Please ask for: Mrs D Johnson
Email: daun.johnson@arun.gov.uk
Telephone: 01903 737762
Our Ref: LU/303/20/PL
Your Ref:
Date: 12th November 2020

Application for Planning Permission

Development: Lean-to storage extension. This application affects the setting of a listed building & is in CIL Zone 2 (Zero Rated) as other development.
Location: Toddington House Toddington Lane Littlehampton BN17 6JX

West Elev
1:100 @ A3

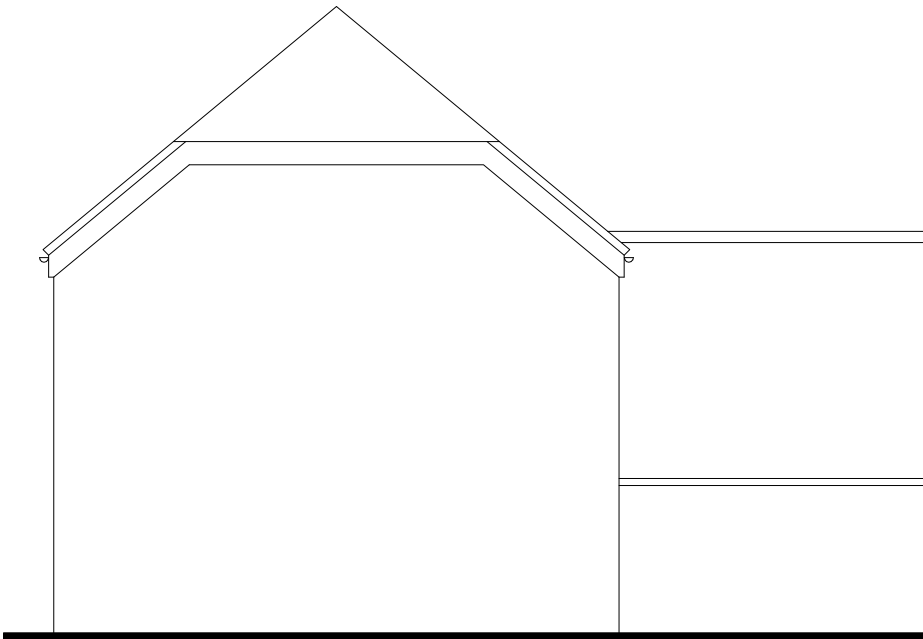
The existing and proposed West elevation should be labelled East. Please amend accordingly.
